# CITY OF ALBUQUERQUE

May 3, 2019

**Re: 601 Commercial renovation**  
**601 Commercial St. NE Albuquerque NM**  
**Traffic Circulation Layout**  
Engineer's/Architect's Stamp **04-22-2019 (J14D124)**

TCL-1

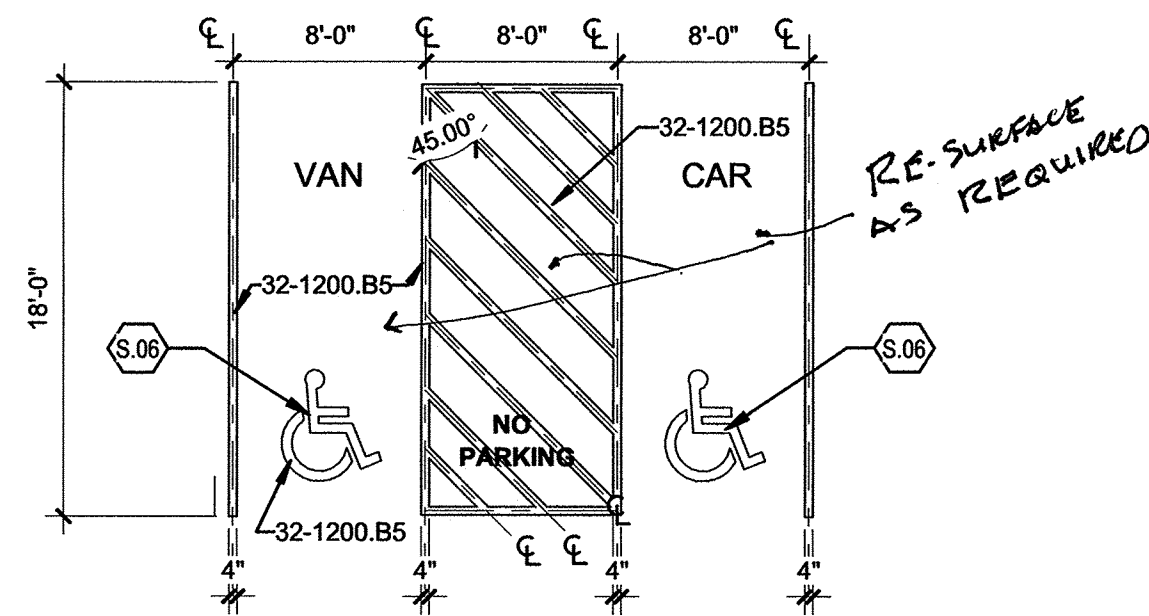
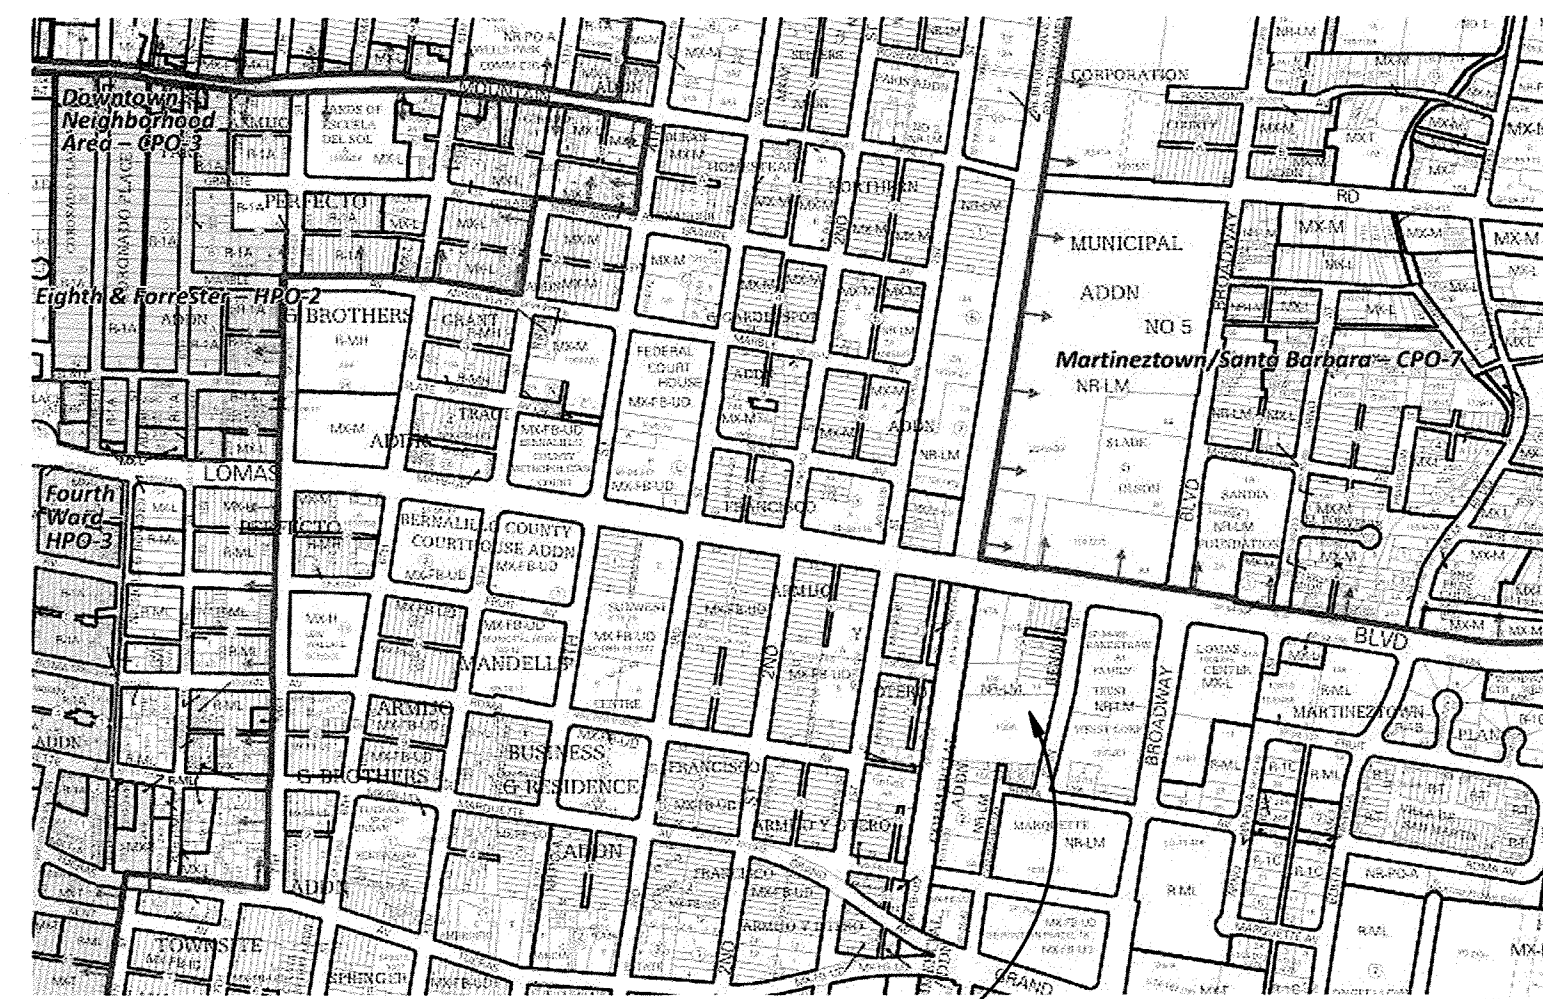
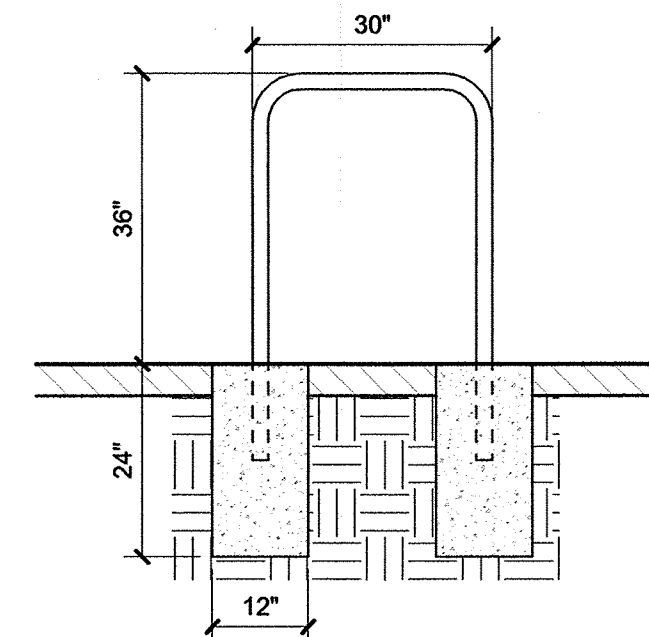
1. Provide a min 6" or max 8" high concrete barrier curb or other acceptable barrier between landscaping and parking areas and/or drive aisles. Please call out detail and location of barrier curb.
2. Please include a copy of your shared access agreement with the adjacent property owner. The access on Commercial street is providing access to more than one property.
3. Motorcycle parking spaces shall be designated by its own conspicuously posted upright sign, either free-standing or wall mounted per the zoning code.
